Re: Submission to Modification Proposal - Epiq Lennox Head MP 07_0026 MOD 7

I refer to your email of 8 July 2022 regarding an amended application to modify the current approval relating to Super Lot 5 in the Epiq Estate at Lennox Head.

The following comments are provided by Council staff from a technical perspective for consideration by the Department in the assessment and determination of the modification application.

## EPIQ LENNOX HEAD ILLUSTRATION C8 - LOT TYPOLOGIES

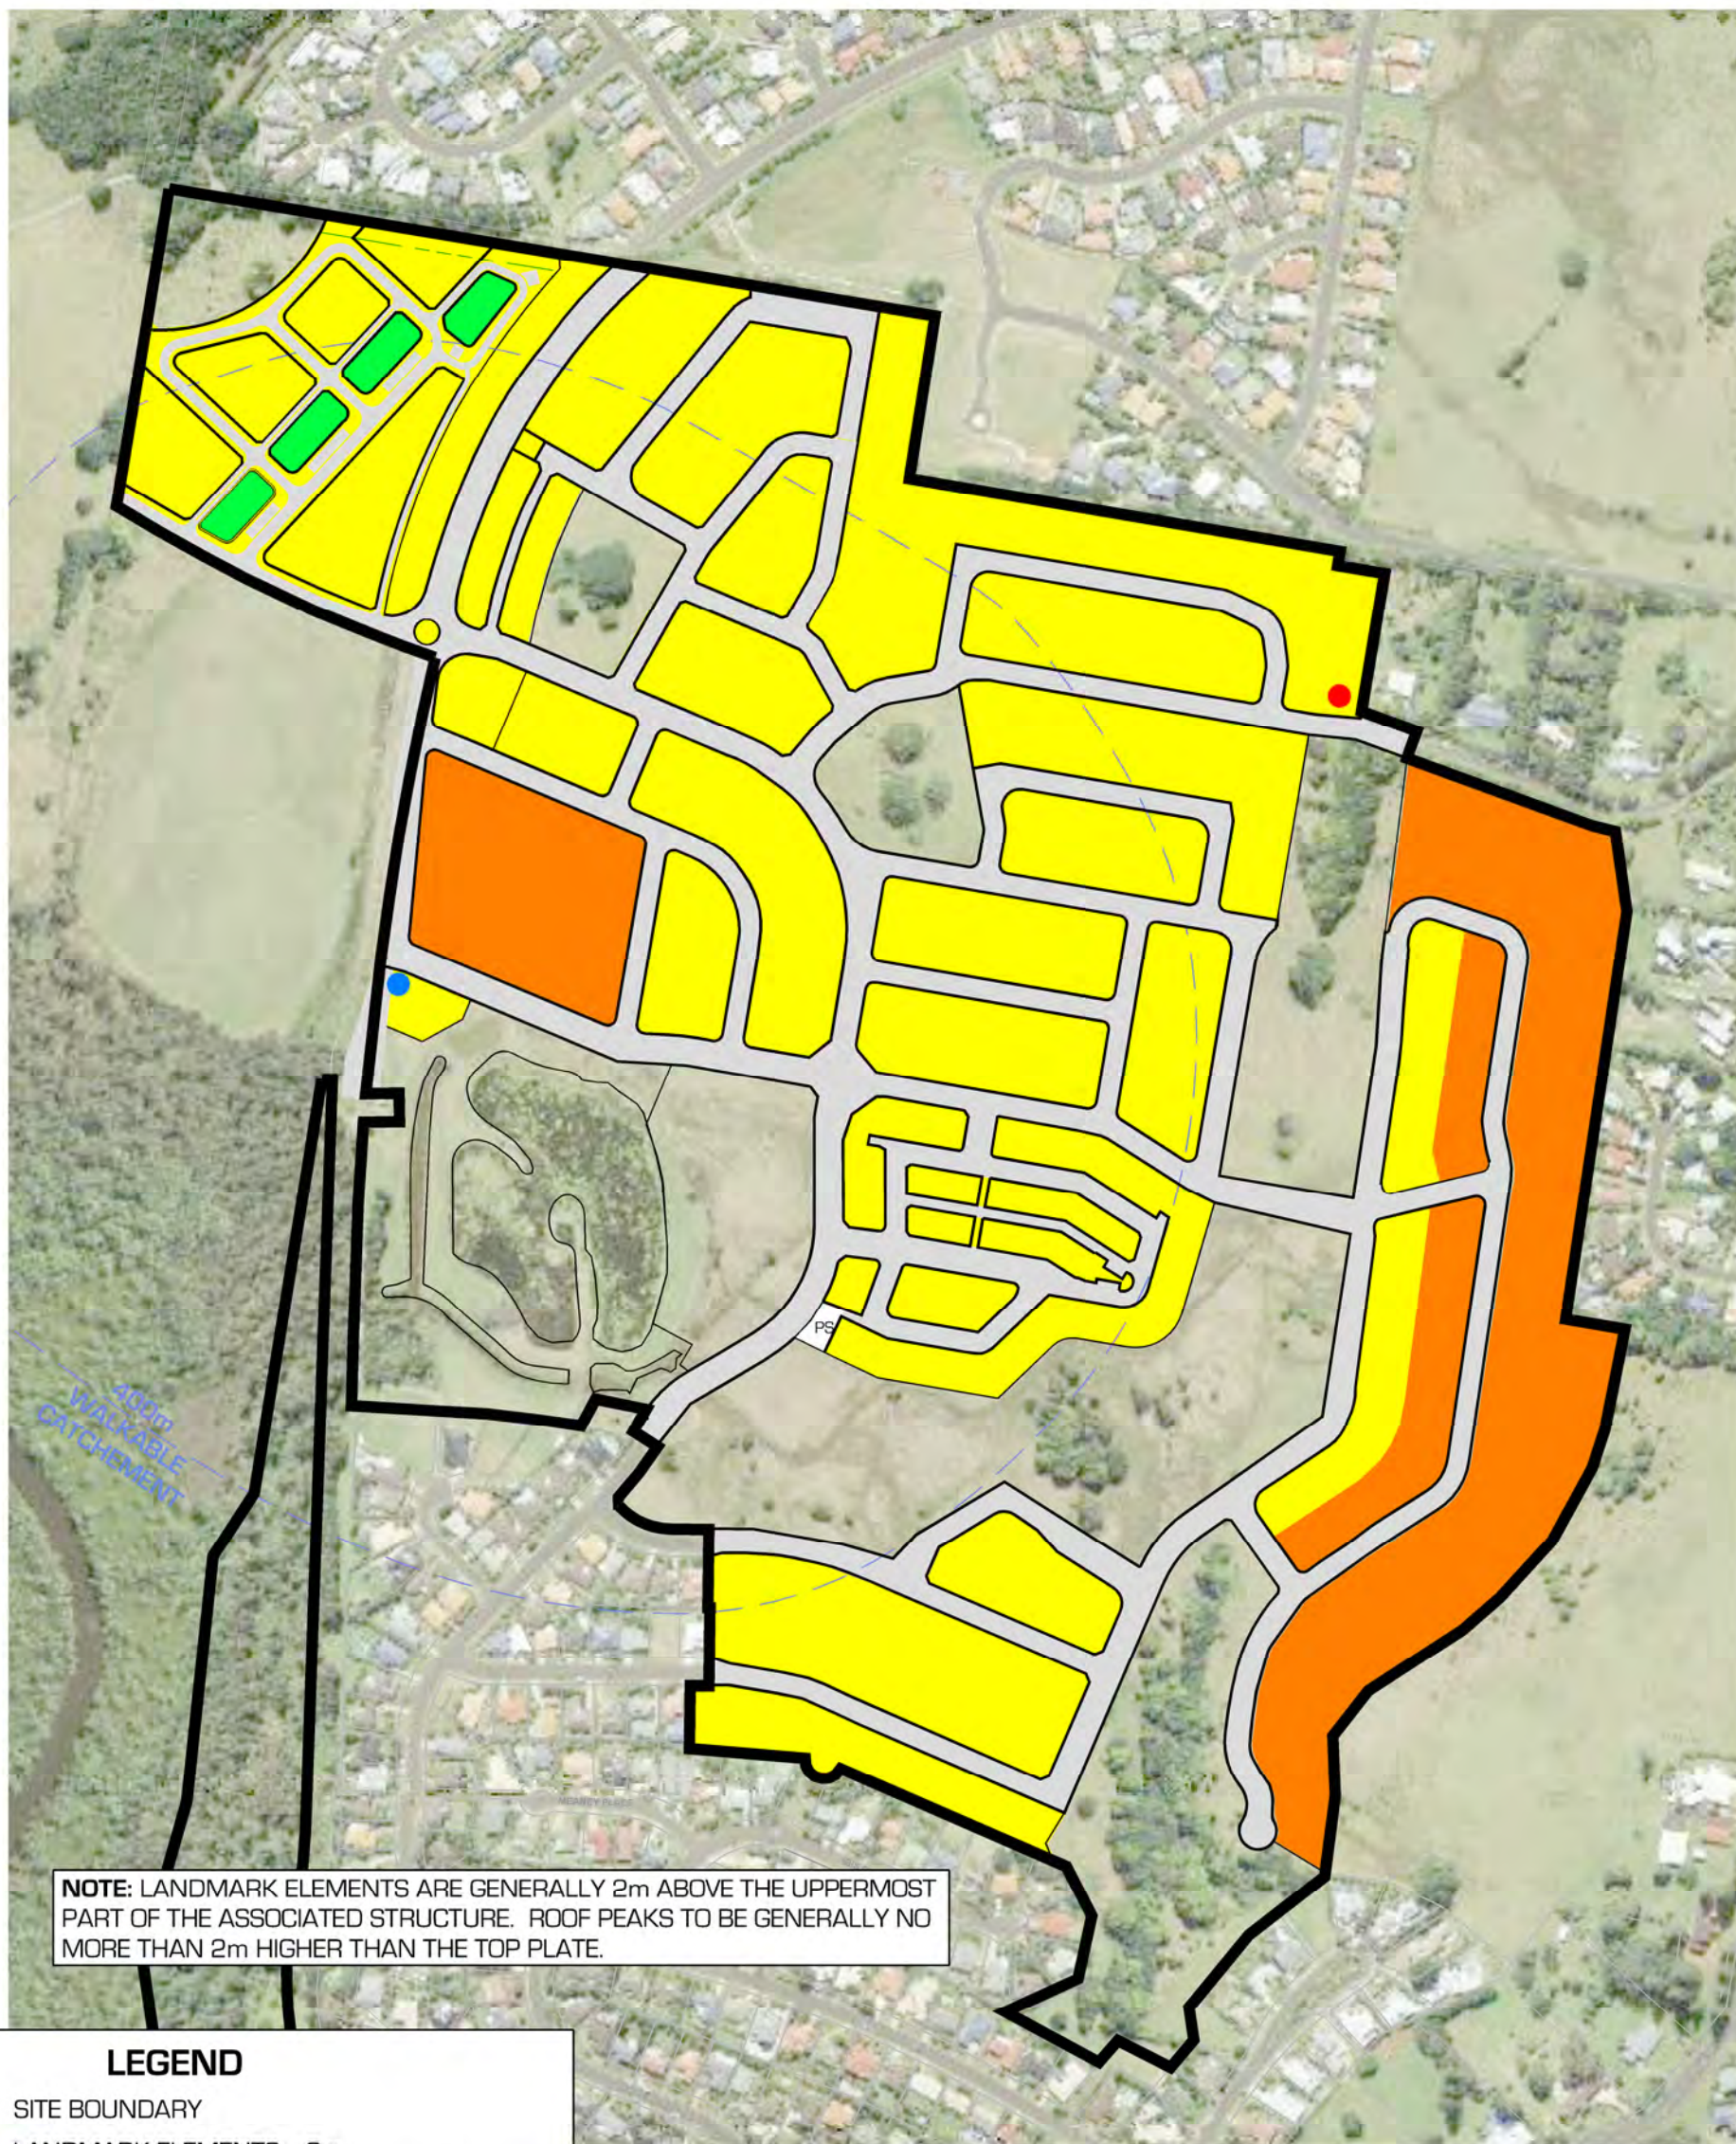
Council has previously raised the provision of a perimeter road to separate development on Super Lot 5 from the conservation zone.

As can be seen from plan Illustration C8 (Plate 1), perimeter roads are used throughout the estate to separate the residential portions of the site from the conservation zone and this type of approach is typical in situations of this nature. This is also consistent with what was anticipated on this land with Illustration C8 showing a perimeter road separating the majority of the concept approved retirement lots on Super Lot 5 from the conservation zone.

Council's preferred approach is for the design to incorporate a perimeter road, particularly on the basis that it provides for a better address of key issues such as bushfire management, mosquito management and conservation zone management.

EPIQ ESTATE - LENNOX HEAD, NSW, 2478
SUPER LOT 5
BULK EARTHWORKS
PLAN

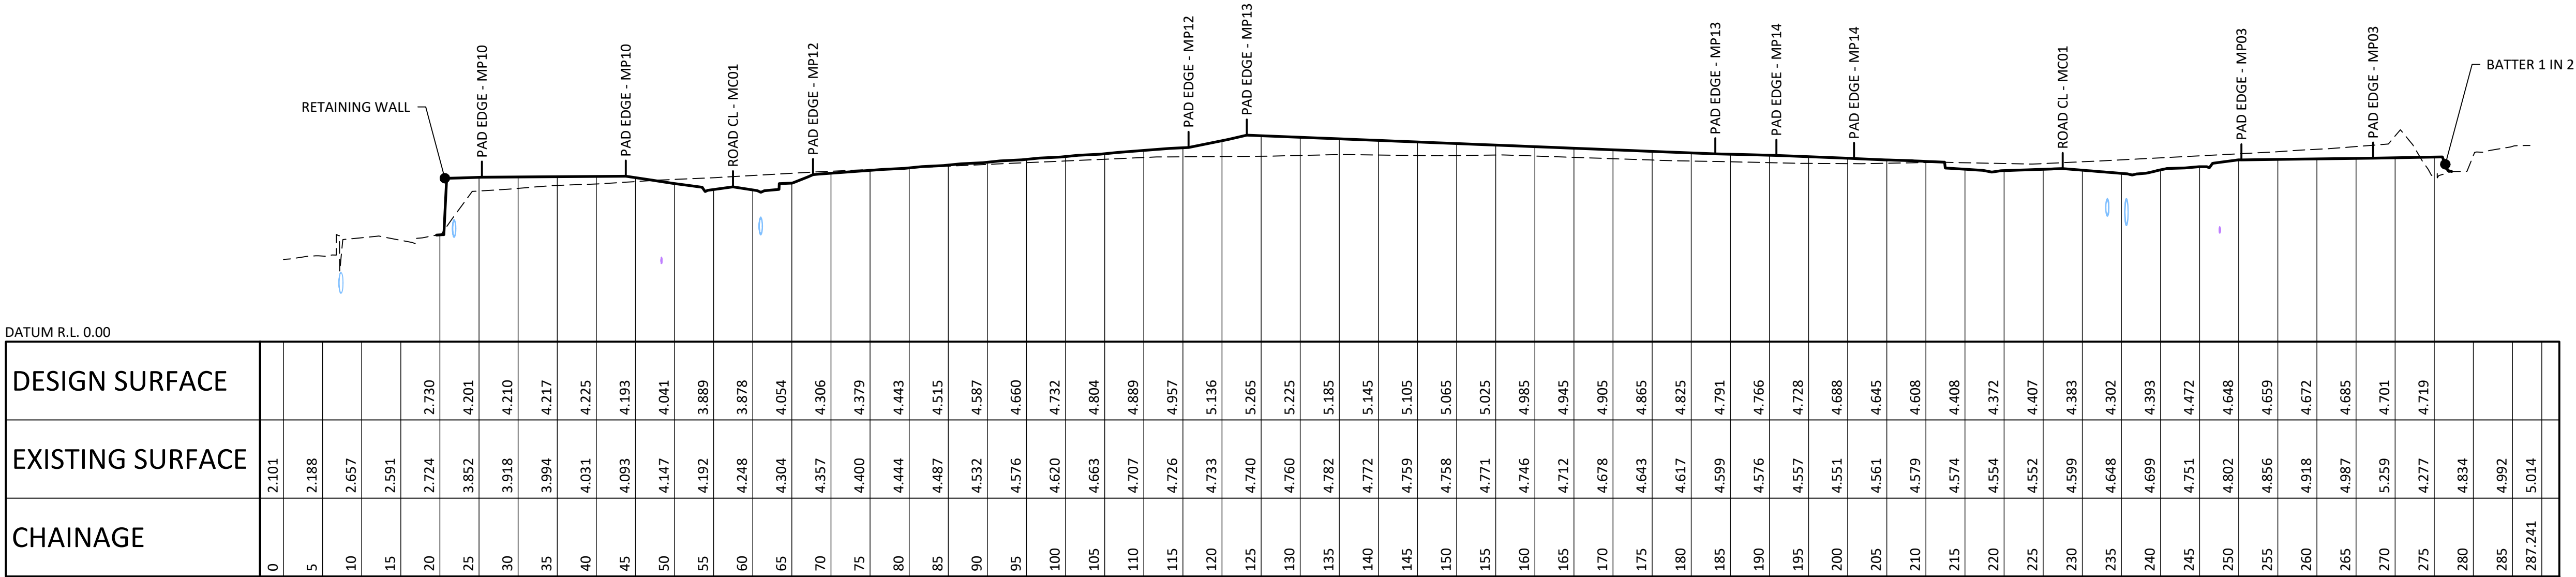
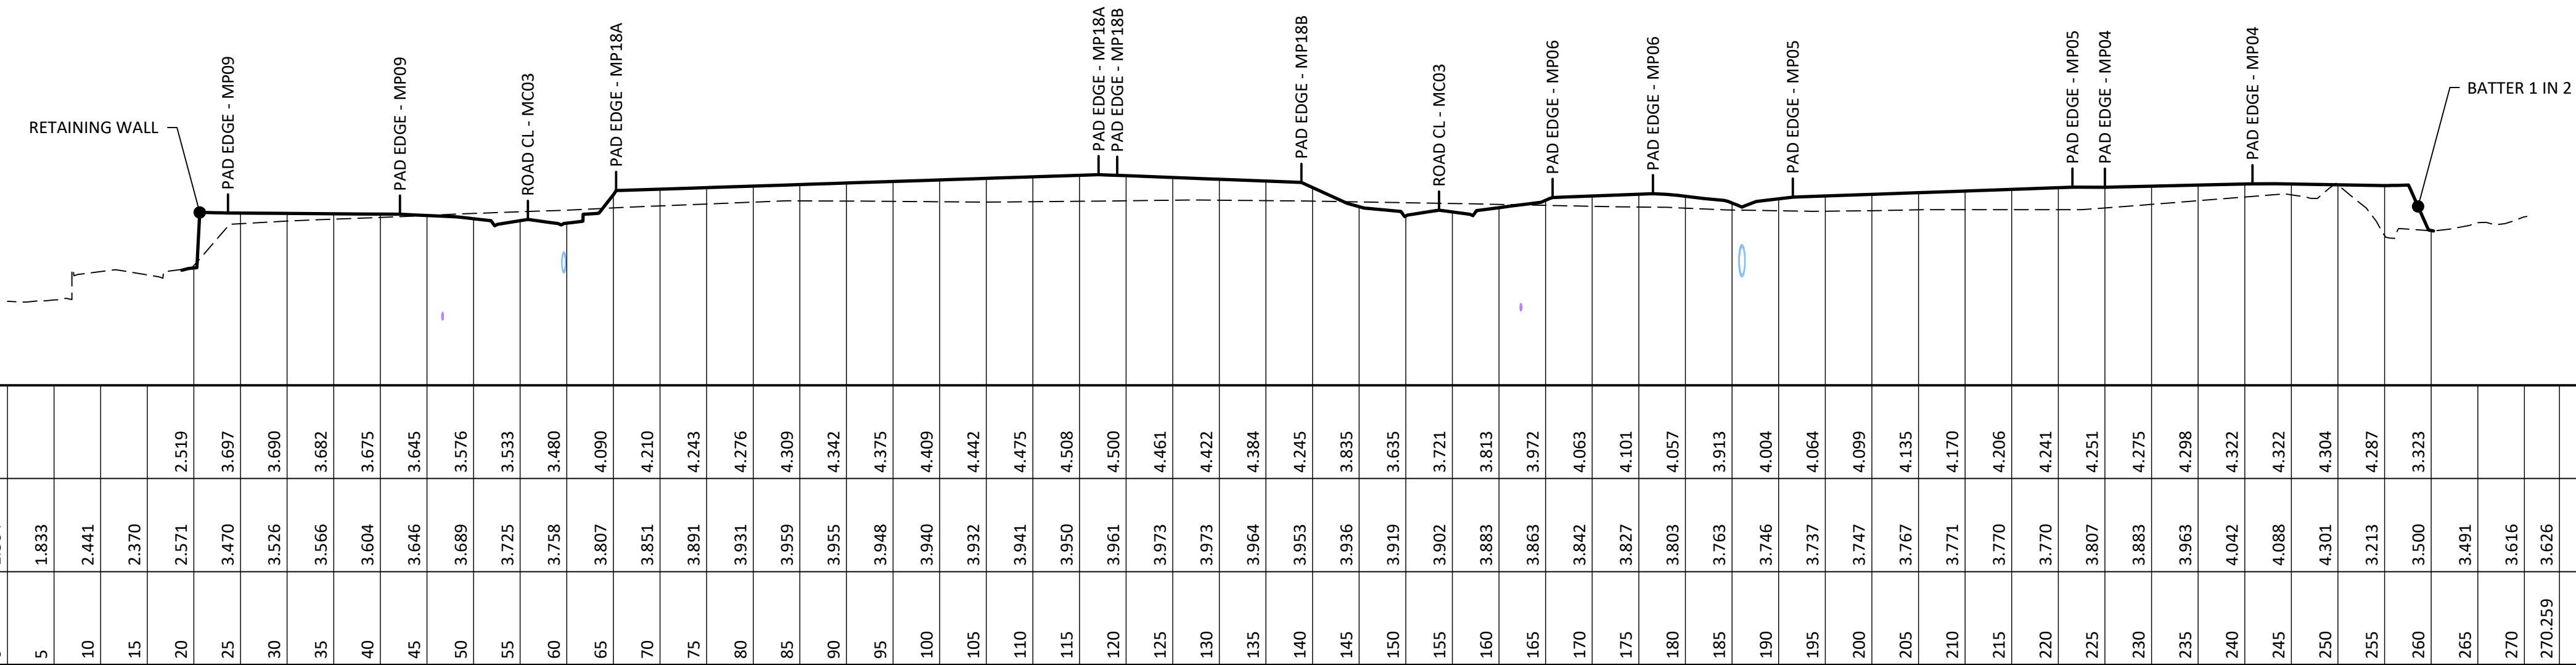
The proposed landform grading and retaining wall design for the proposed park on Lot 203 does not provide an acceptable overland flow path directed to Road 1 and Montwood Drive.

The above changes and the landform grading of proposed lot 203 result in an unacceptable concentration of overland stormwater flows to Road 1 and hence to Montwood Drive.

EPIQ ESTATE - LENNOX HEAD, NSW, 2478 SUPER LOT 5 CIVIL WORKS PLAN		
Reference No. 2014/351	DRAWING No. 14351-S5-DA-CI-01	REVISION B

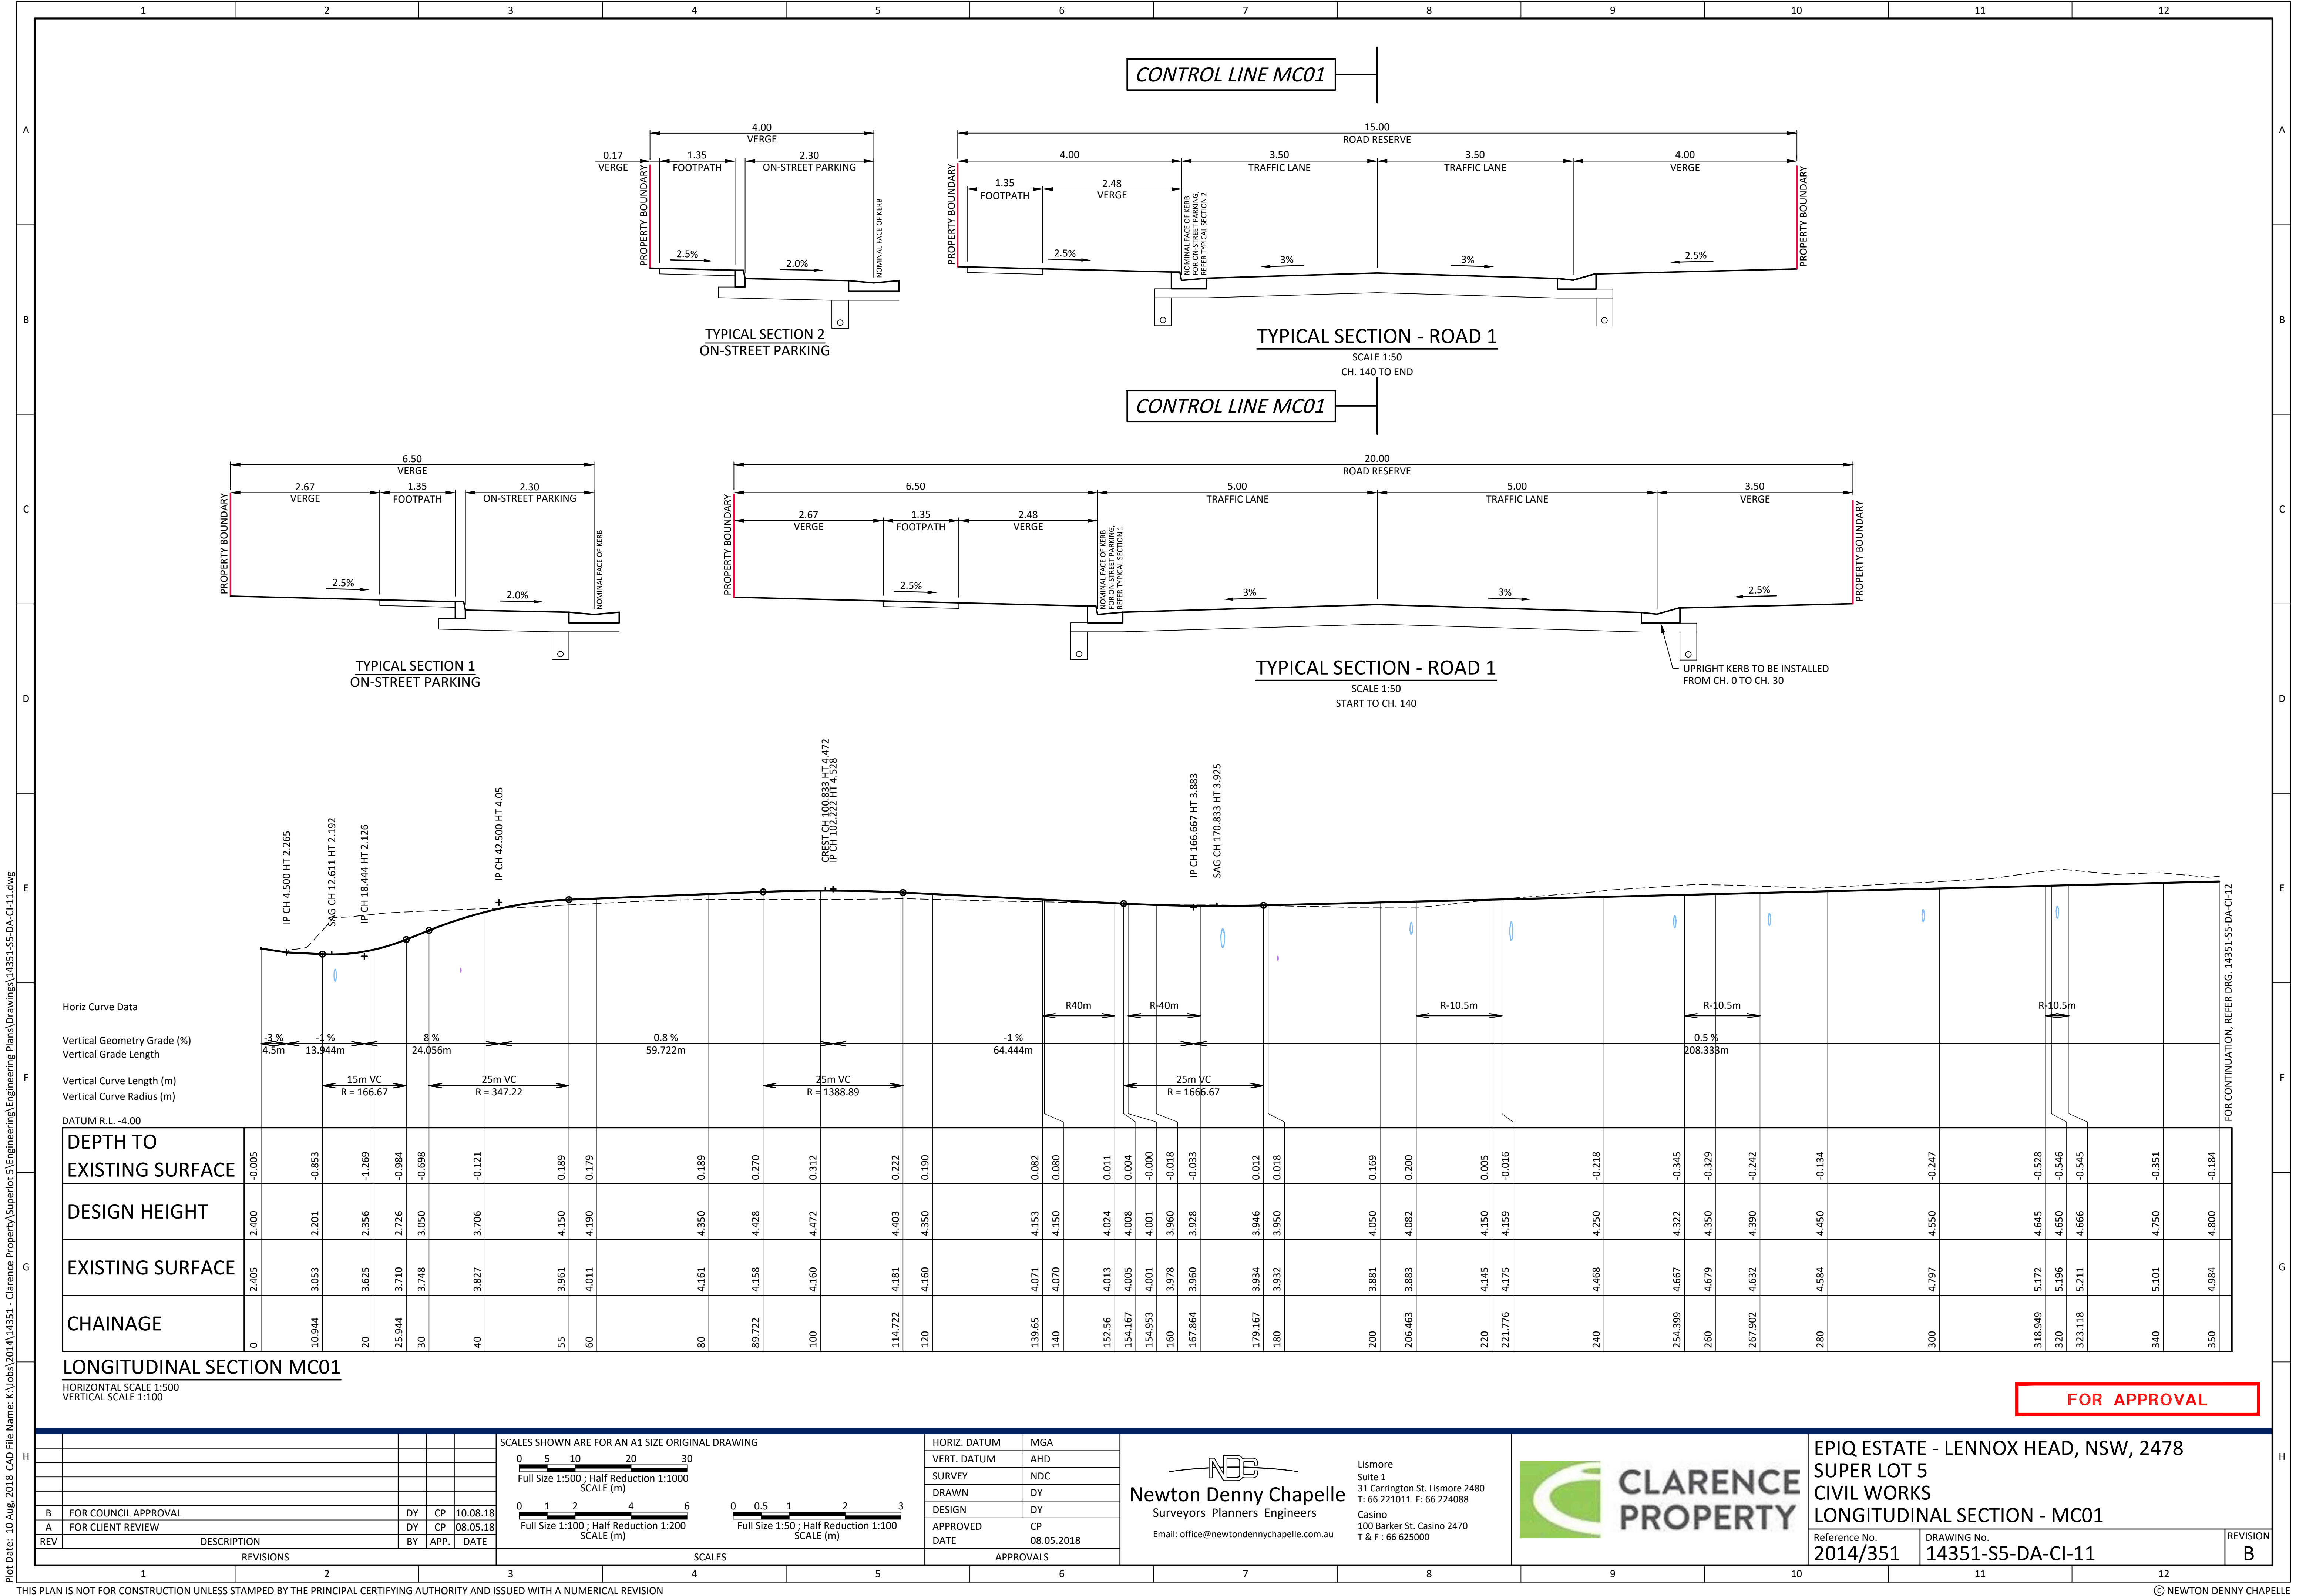
The proposed full function intersection of Road 1 to Montwood Drive in the “updated subdivision design” is not acceptable. This matter was partially addressed by the applicant following exhibition of the August 2018 version of Mod 7 by amending the intersection to left in/left out only. The applicant has now reversed this remedy. In Council’s letter to the Department RN 20/54210 dated 5 August 2020 it was advised:

Council’s position on the issue remains unchanged. A full function intersection is not acceptable. A left in/left out intersection may be considered acceptable, subject to detailed design process to determine if widening of Montwood Drive is required to accommodate the central median required to prevent right turns.

The applicant has not determined driveway locations or demonstrated that proposed driveways can be located to provide sufficient sight distance for drivers. There is concern that the indicative landscaping submitted will obstruct sightlines from driveways and increase safety risk.
